From: Judith Ward
Sent: 10 December 2020 15:19
To: Linda Griffiths
Subject: 20/01162/DISC OS Parcel 7400 adj and south of Saltway

Judith Ward
Landscape Planning Officer
Cherwell District & South Northants Councils

TITLE: PROPOSED DETENTION BASIN CROSS SECTIONS

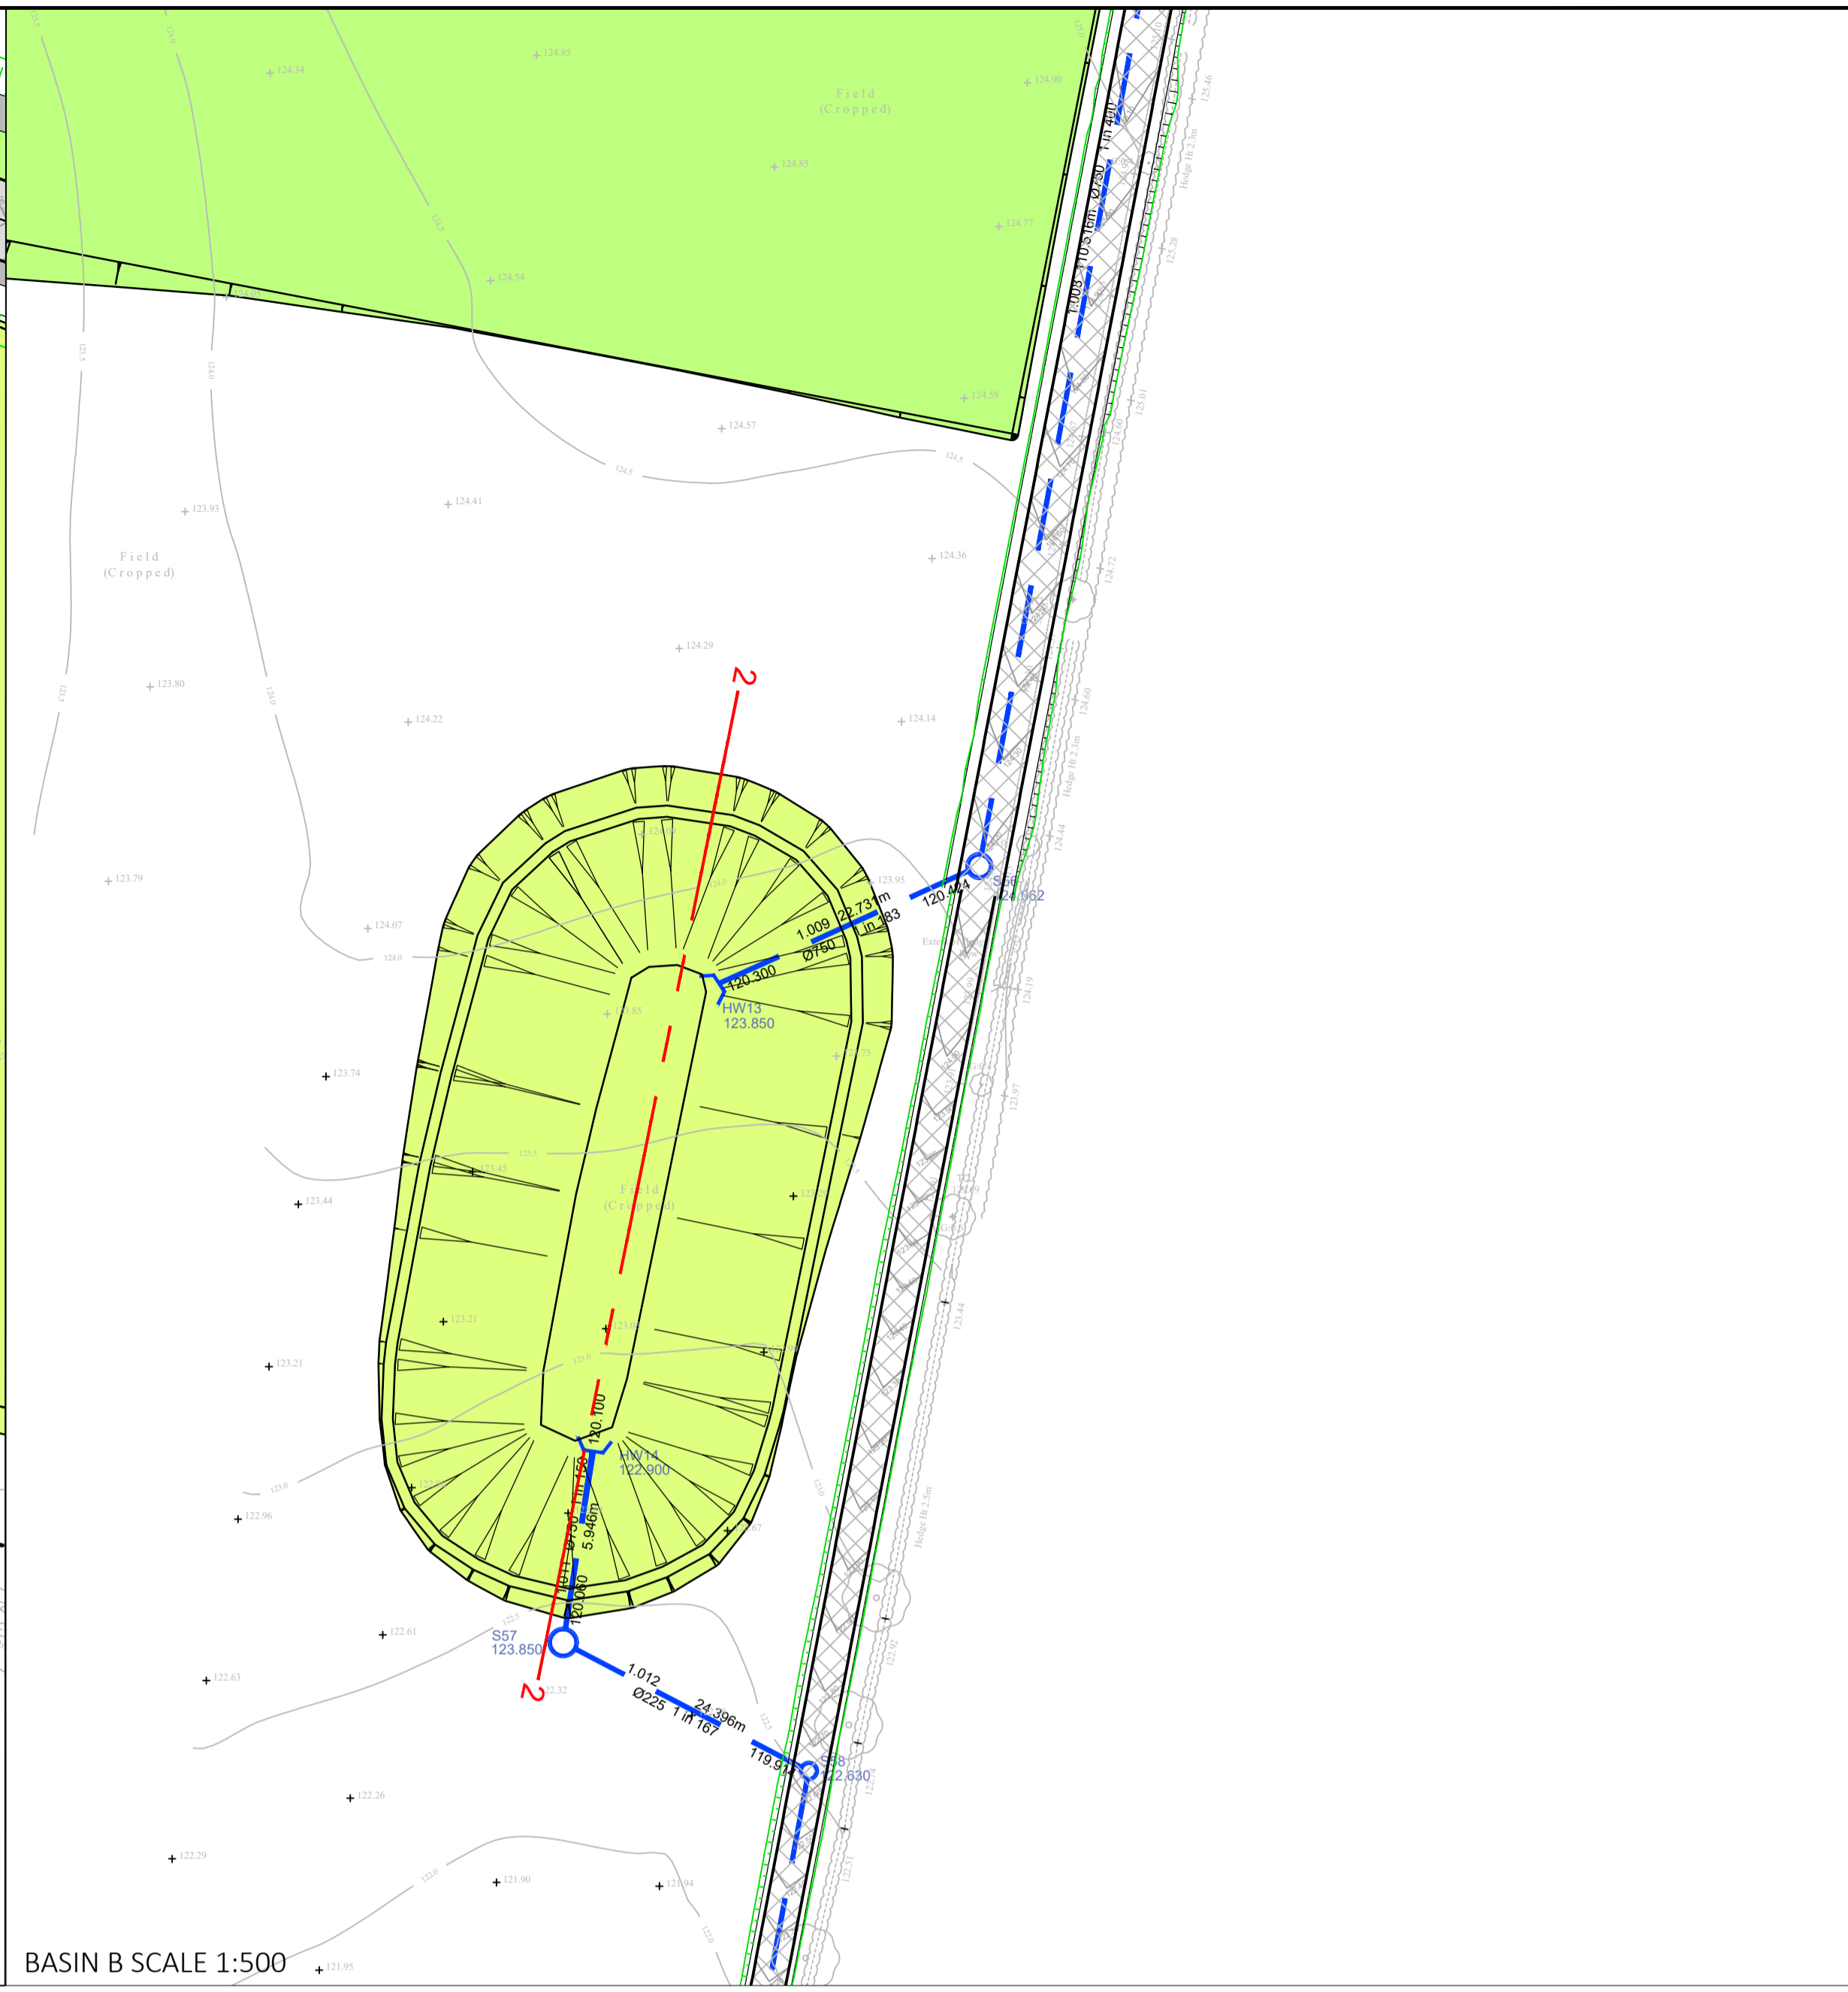
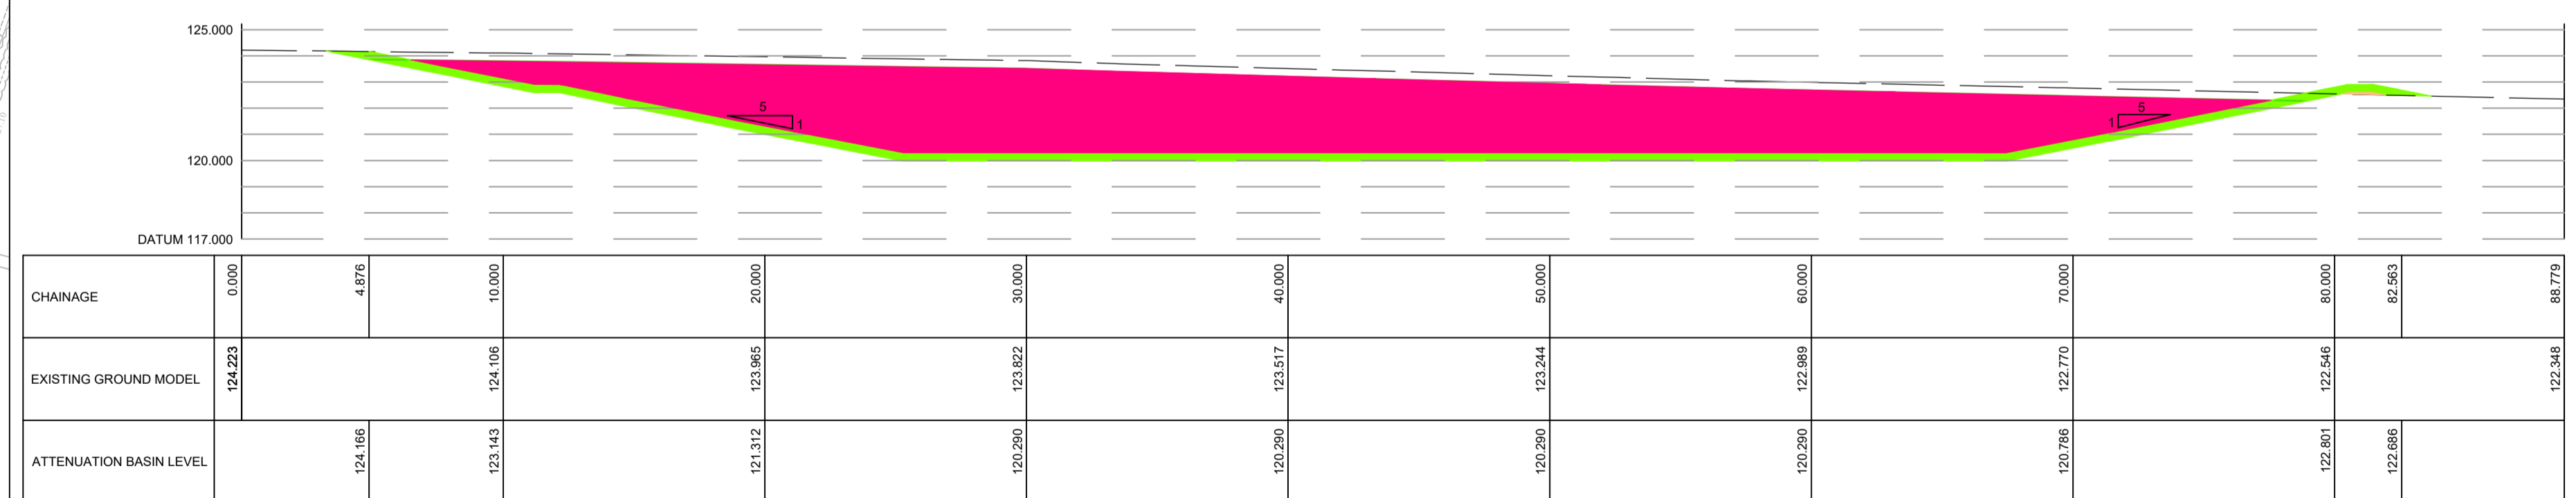
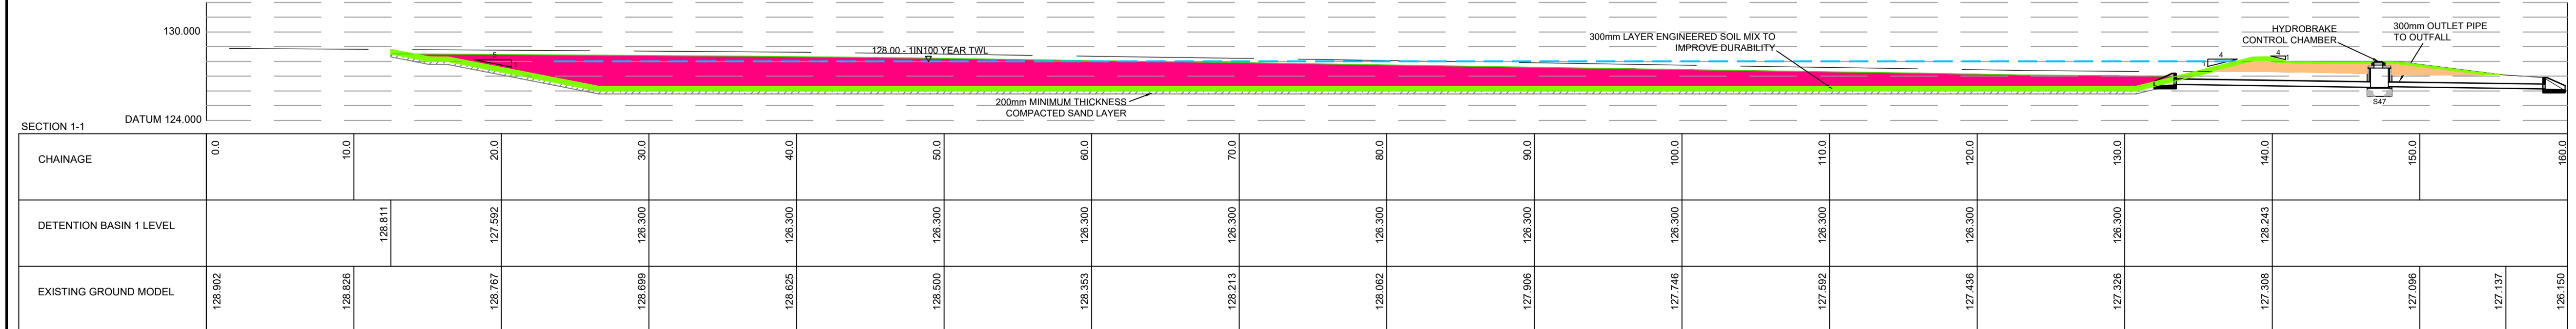
Detention basin B is 5m deep. Is it expected that there will be standing water in these basins? If so then I think there could be a big safety concern here. If someone fell in no-one would see them. I think we need further information.
